# Medworth Energy from Waste Combined Heat and Power Facility

PINS ref. EN010110  
Document Reference Vol.16.2  
Revision: 1.0  
Deadline: 7  
August 2023

## Applicant's response to the ExA's Written Questions (ExQ3)

DCO Requirement 29: Waste Area Plan

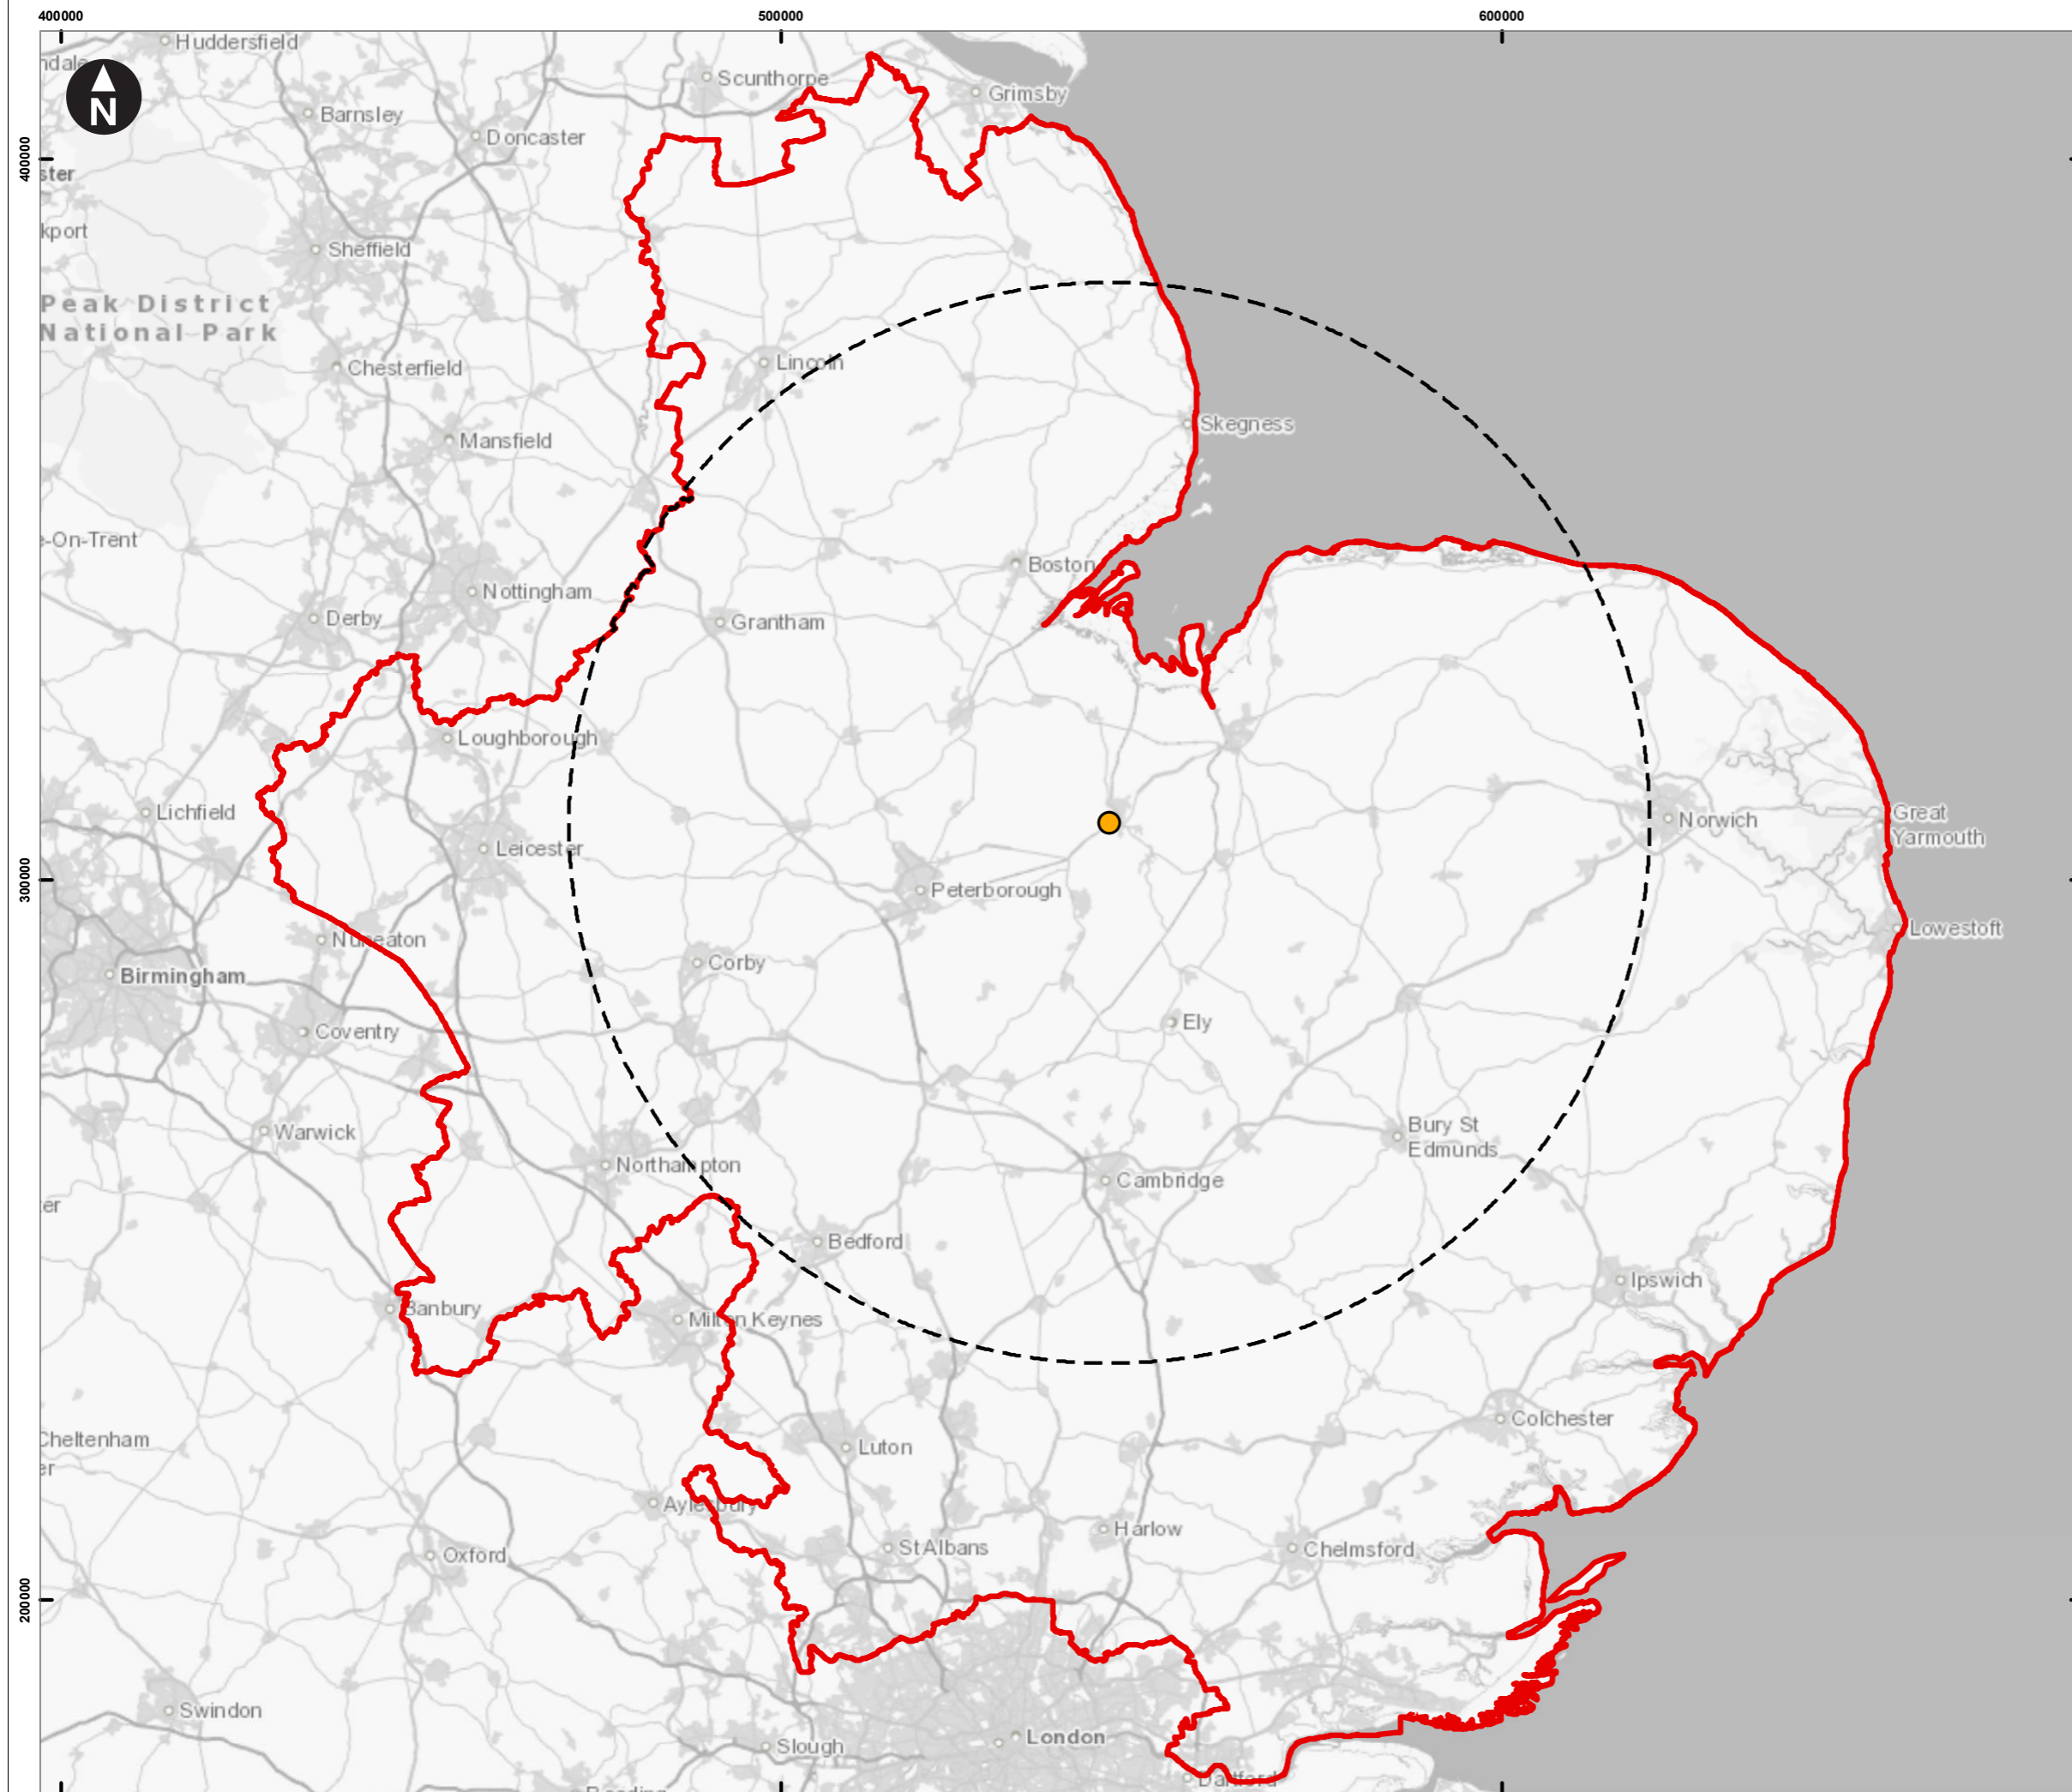
ExQ3	Question to	Question	Applicant Response
PND.3.6	Applicant	<p>DCO Requirements 29: Waste Area Plan [REP6-015] includes a Plan showing Waste Area 1 (75km from the Proposed Development) and Waste Area 2. Considering that the vast majority of the waste anticipated to fuel the Proposed Development could potentially come from Waste Area 2 (with 80% to 100% of the waste coming from this area with potentially only a contribution of 17.5% from Waste Area 1) how does the Applicant guarantee that the Proposed Development will not displace waste from any of the local waste planning authorities included in Waste Area 2 which could be processed closer to its source? The Applicant is asked to provide evidence of this work.</p>	<p>Notwithstanding the above, the requirement to source 17.5% of waste from Waste Area 1 has been agreed with CCC and is a minimum. It does not prevent the Applicant from sourcing a greater percentage of waste from closer proximity. Because the cost of disposing of waste is heavily influenced by the cost of transport, the Applicant is confident that economics will encourage waste producers and processors located within Waste Area 1 to use the Proposed Development.</p> <p>The Applicant refers the ExA to the <b>WFAA (Rev 3.0) [REP5-020]</b>, being the evidence base that demonstrates that there is sufficient residual waste, i.e., waste that is currently being sent to landfill within the Study Area, available for the Proposed Development, to avoid displacing waste from any local waste planning authorities within Waste Area 2 that could be processed closer to its source.</p> <p>Waste Area 2 is equivalent to the Study Area identified within the <b>WFAA</b>. As such, any waste that originates from Waste Area 2 will have been taken into consideration within the <b>WFAA</b>.</p> <p>The Proposed Development will not displace waste from any existing energy recovery facilities as it will be sourcing fuel from residual waste within the Study Area that is currently sent to landfill. As demonstrated clearly by the <b>WFAA (Rev 3.0) [REP5-020]</b>, there is sufficient waste that is currently being treated at landfill available for the Proposed Development and</p>

ExQ3	Question to	Question	Applicant Response
			<p>the Proposed Development will not result in any over-capacity of EfW treatment at either a national or local level.</p> <p>The Proposed Development will offer much needed capacity in the Study Area that moves the management of residual waste further up the waste hierarchy. Through reviewing the Local Plan evidence bases of those Waste Planning Authorities within the Study Area, it has been demonstrated that of the sixteen Waste Planning Authorities considered, only three (Central Bedfordshire, Bedford and Luton, who operate under one single Waste Local Plan) had any planned surplus in residual waste management capacity. The overwhelming majority of the WPA's considered had predicted planned shortfalls in residual waste management capacity. In this regard, it is considered that the Proposed Development is highly unlikely to displace waste from any of the local waste planning authorities included in Waste Area 2 as the majority of these areas are already planning for shortfalls in capacity.</p> <p>Given the quantity of residual waste withing the Study Area (i.e., Waste Area 2) currently being treated at landfill, as demonstrated by the <b>WFAA</b>, the ExA can be confident that there is sufficient waste to fuel all existing EfW facilities and the Proposed Development.</p>
